Please ask for: Ms Iqraa Malik
Email: iqraa.malik@terraquest.co.uk
Telephone: 01212341390
Our Ref: AW/159/21/HH
Your Ref:
Date: 28th April 2021

Application for Planning Permission for Works or Extension to a Dwelling

Development: Loft extension with 3 x rear dormers
Location: 25 The Drive Aldwick PO21 4DU

4 Site  
1 : 200

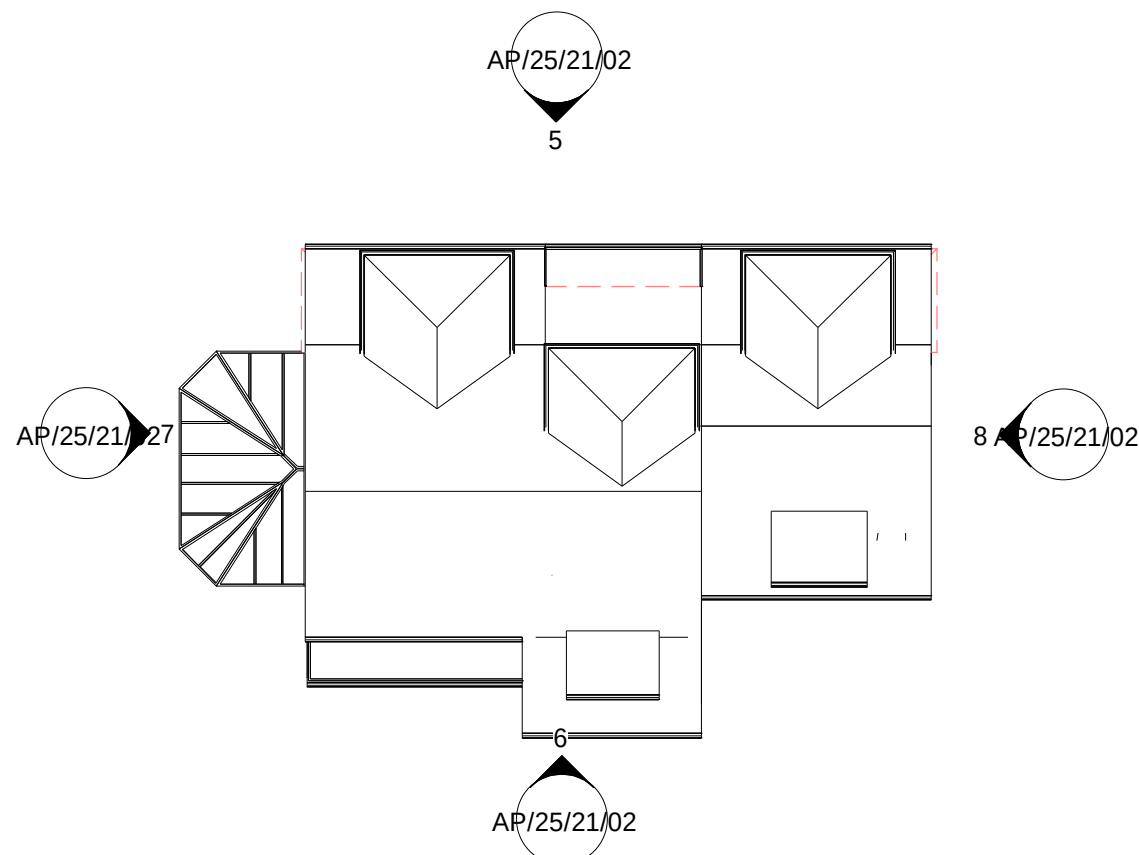
Block Plan

You are required to have dimensions from the proposed extension(s) to all site boundaries. Please amend
